PROJECT TITLE: HORIZON VANS

RE: HORIZON VANS (G16-D120). GRADING AND DRAINAGE PLAN FOR BUILDING PERMIT AND SO#19 PERMIT APPROVALS. ENGINEER'S STAMP DATED FEBRUARY 2, 1999.

RE: HORIZON VANS (G16-D120). GRADING AND DRAINAGE PLAN FOR BUILDING PERMIT APPROVAL. ENGINEER'S STAMP DATED FEBRUARY 2, 1999.

RE: Horizon Vans - Grading and Drainage Plan

HORIZON VANS  
GRADING AND DRAINAGE PLAN

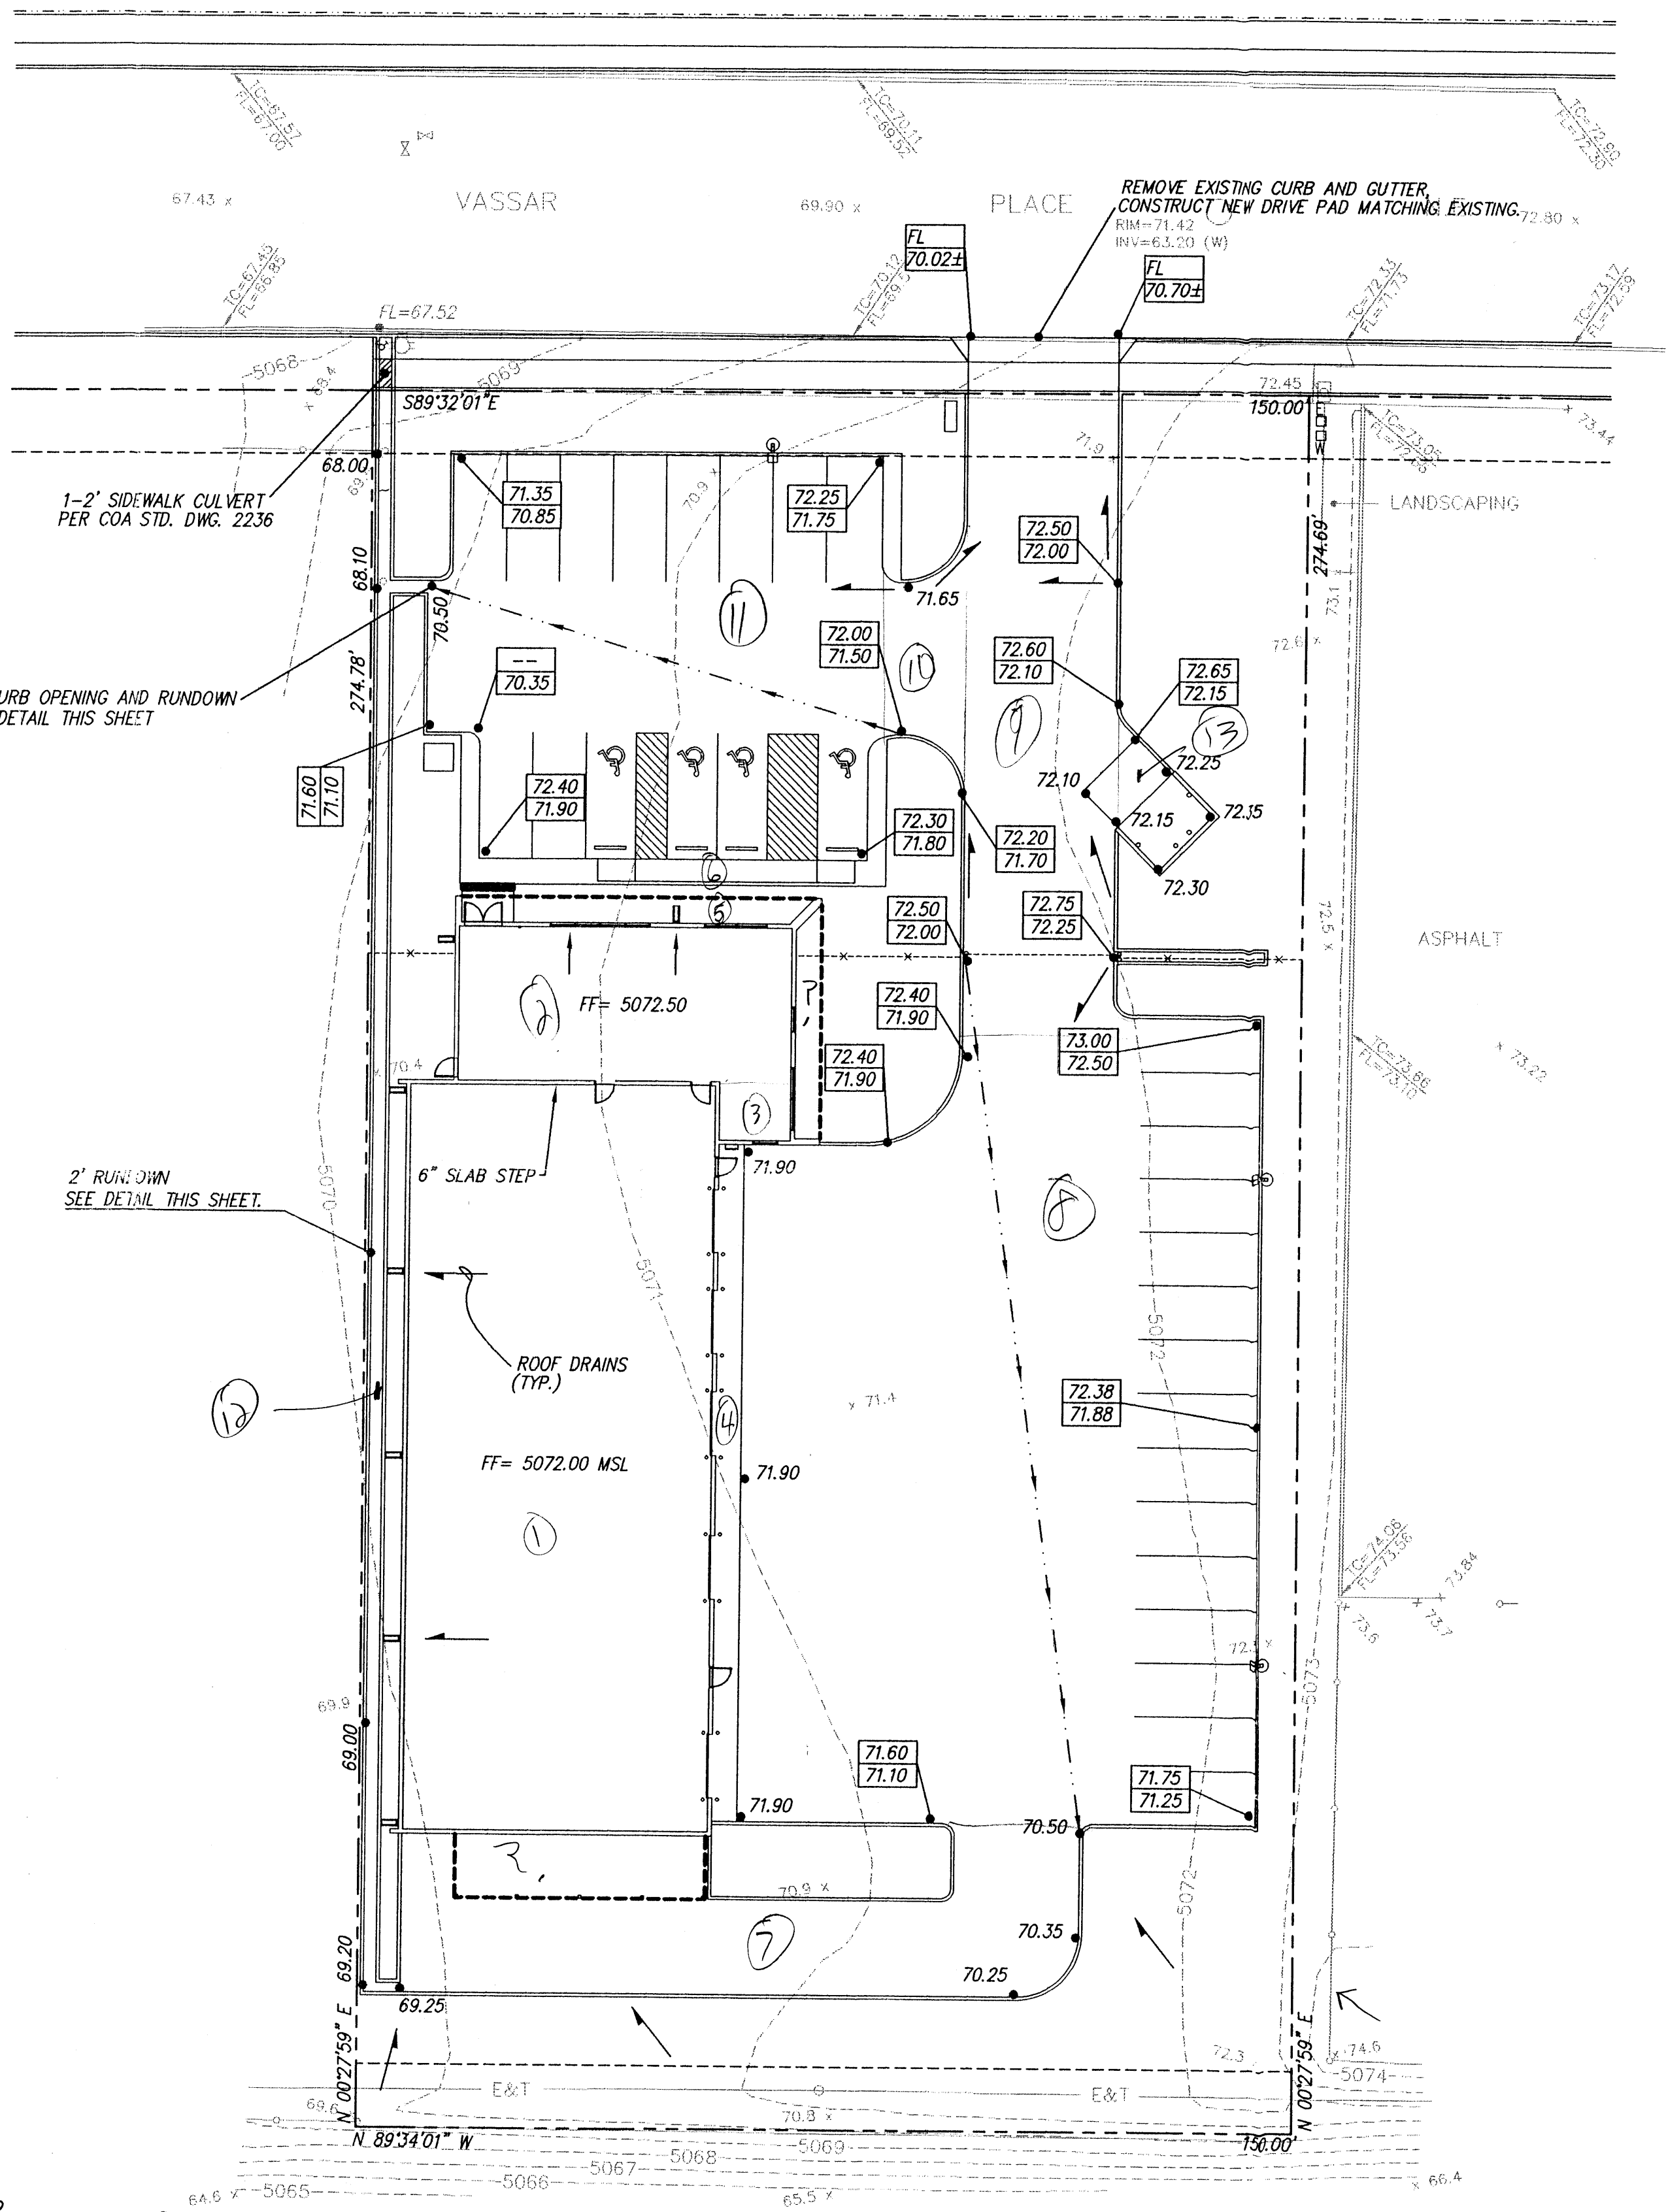
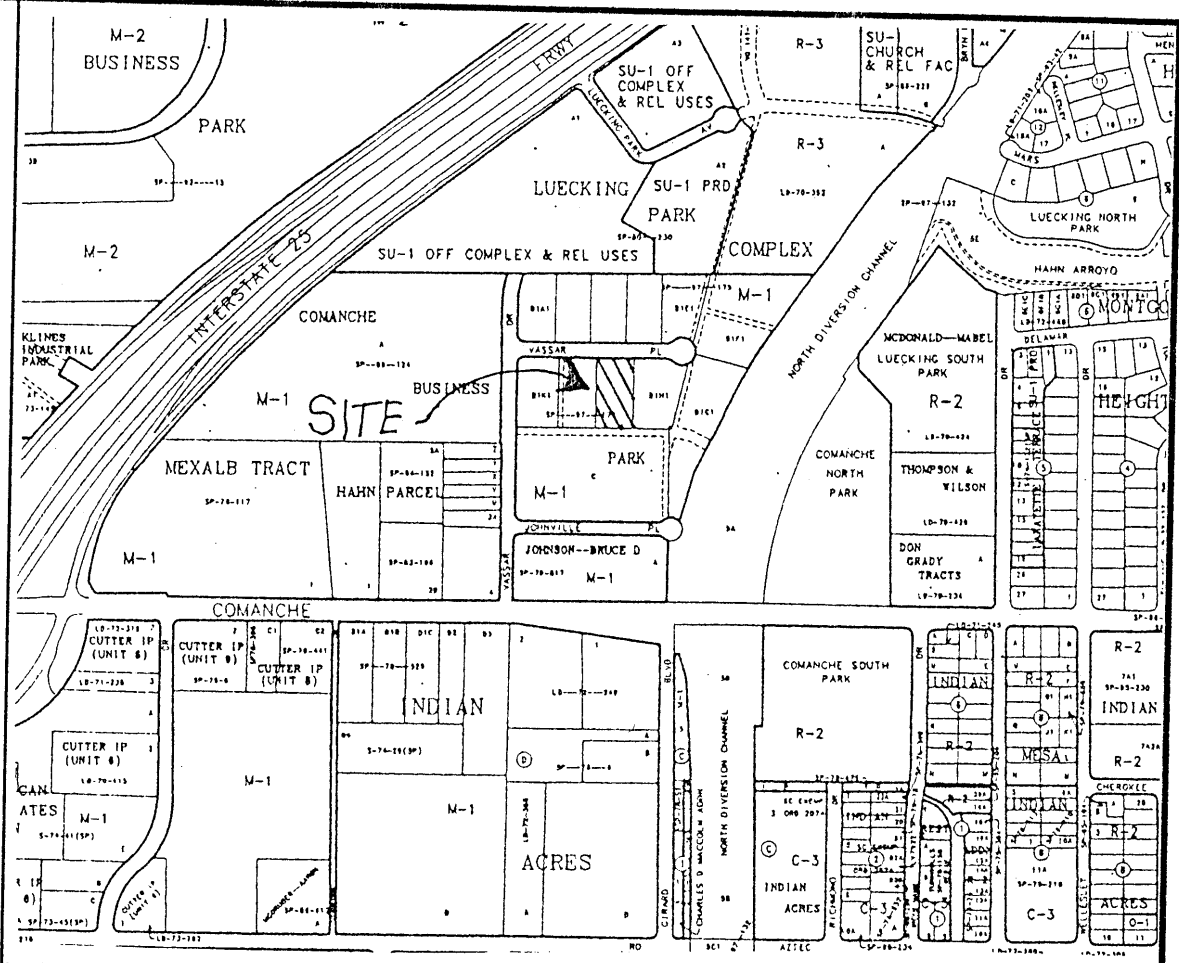
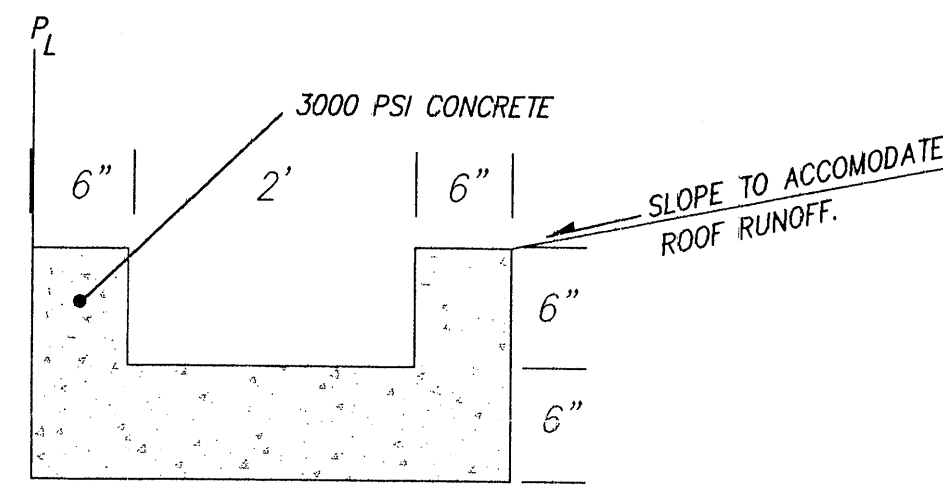
- 3.41
CFA
P.S.
1. Land Treatment Percentages - The % D listed is 55%, this appears to low so I did a rough calculation and computed 69% D. Some of the areas on the plan are not specified as to what they will be so I made the best assumptions I could. My calculations are attached and correspond to Sheet 1 of 1 (the grading and drainage plan). I believe the % D is too low and should be recomputed and changed. If the %D is increased, that will push the computed discharge over the allowable limit because now the Q100 is shown as 3.35 cfs and the allowable for the site is ~~3.31~~ 3.31 cfs. I did not compute the % land treatment types for A, B or C. A legend or some labeling as to what various parts of the lot will be (landscaping, sidewalks, bare ground, etc.) would be EXTREMELY HELPFUL.

2. It appears the formula for the weir equation is incorrect. The exponent on H is shown as 0.5 and I believe should be 1.5. The assumed value for H is not given. What is the value assumed for H?

3. What are the values assumed for the Mannings's Equation Calculation??

N = ? Depth and area = ?? Rh = ? S = ?

4. The plan states that off-site flows do not impact the site. However, it appears from the plan that there may be flows that enter the southeast corner of the site from a portion of the adjacent lot. ??

5. The hydrology calculations are really non-existent. The data is presented but no calculations. The Q100 is presented by no Volume (V100) is given. Where are the calculations??

LAND TREATMENT % A DO NOT LOOK
CORRECT, CHECK THEM

★ SHEET 1 OF 1 SHOWS 55% D, !
APPEARS TO BE INCORRECT

1. We have re-computed Land Treatments and have changed our calculations accordingly. New $Q_{100} = 3.48$ cfs vs. allowable $Q_{100} = 3.41$ cfs. We consider this negligible. We have added labels as requested.
2. The weir equation typo has been corrected. $H = 0.5$ feet
3. We removed this calculation since it was not necessary. Mannings Equations nomograph shows a capacity of 6 cfs.
4. An area of 420 sf drains into our landscape area from the adjacent landscaped area at our SE Corner. This again is negligible, however, we will remedy the situation with our project.
5. We seldom provide the actual calculations for a project of this magnitude. Design Parameters are provided. The volume has been shown. ✓

#### HORIZON VANS GRADING AND DRAINAGE PLAN

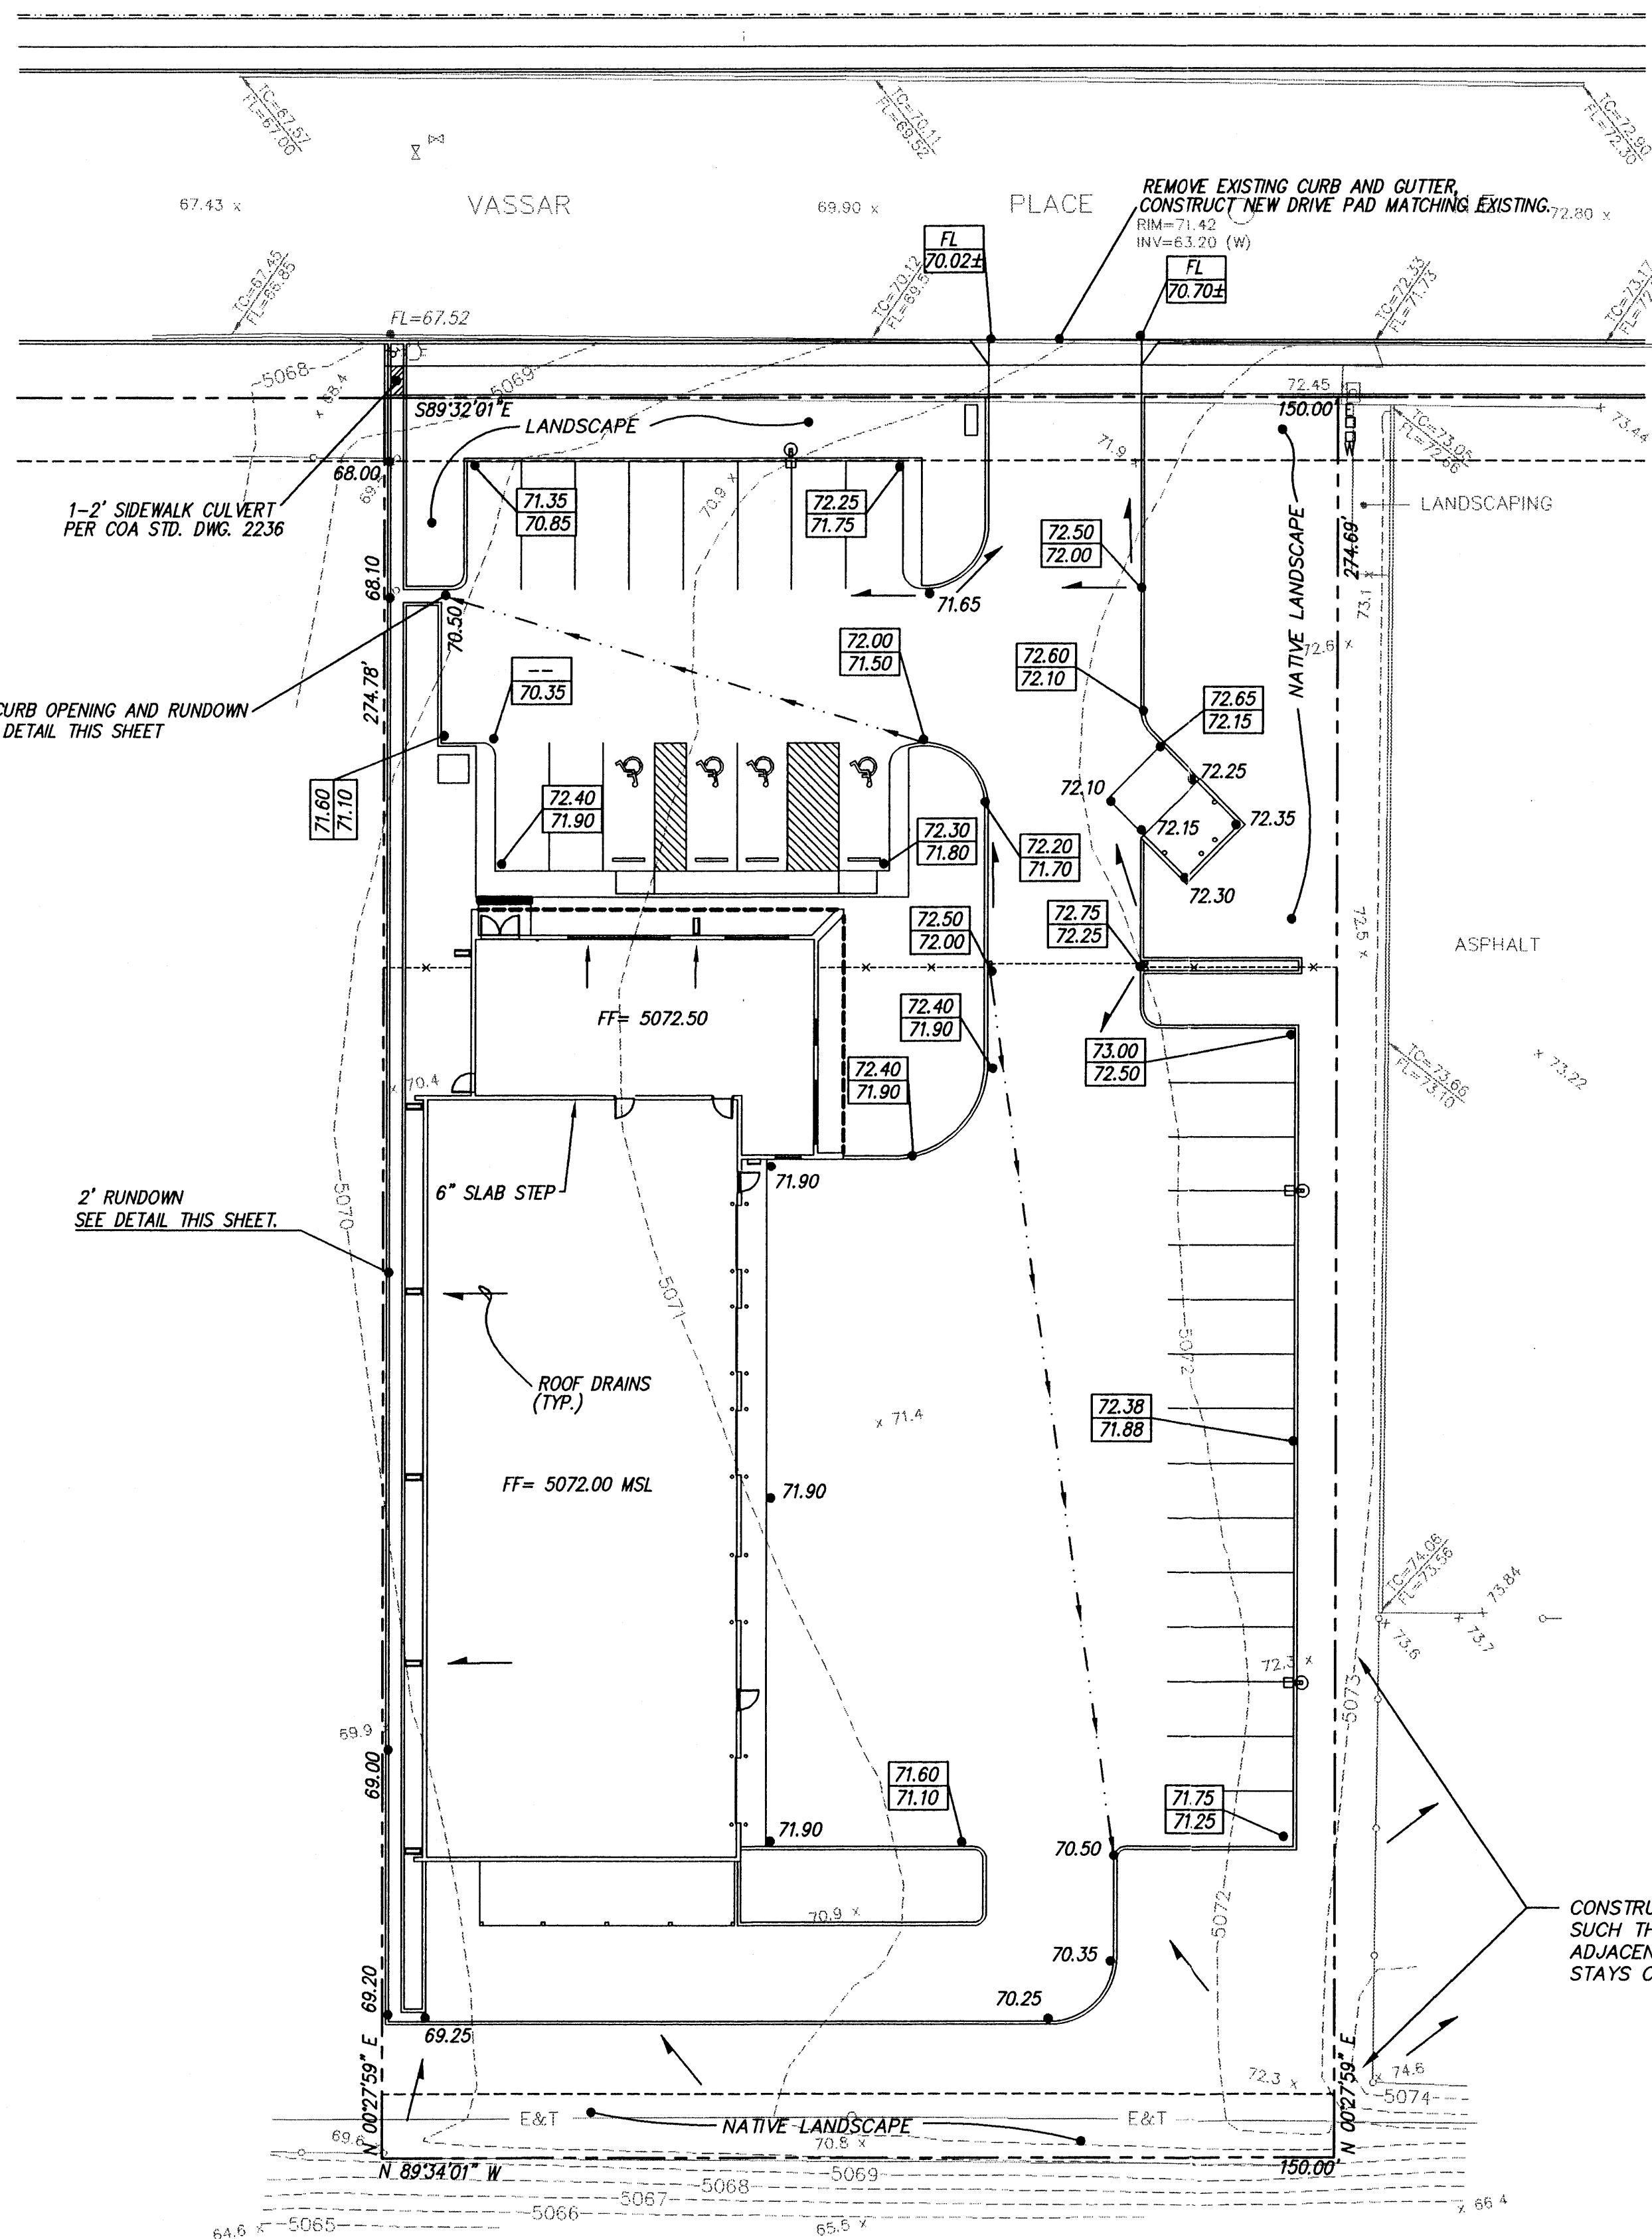
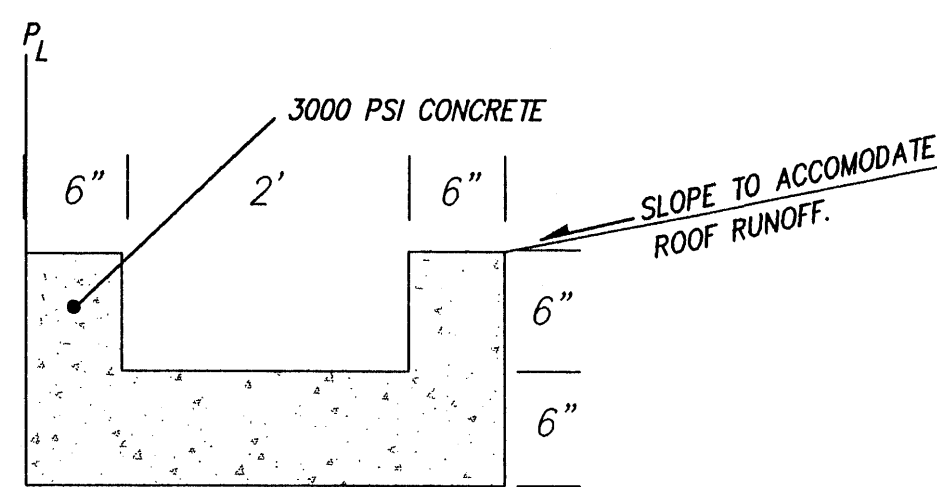
We doubt that you intended the haughtiness of your response regarding hydrology calculations.

For projects this size, C.O.A. has become so accustomed to the Engineer summarizing the data for existing and proposed conditions, usually in tabular form, as to consider it standard. Columns are headed: Basin, Area, Treatment - A, B, C, and D, V360 (ac-ft), Q100 (cfs), with totals for Area and Q100.

The two (2) percent increase in discharge - 3.48 versus 3.41 cfs - is acceptable.
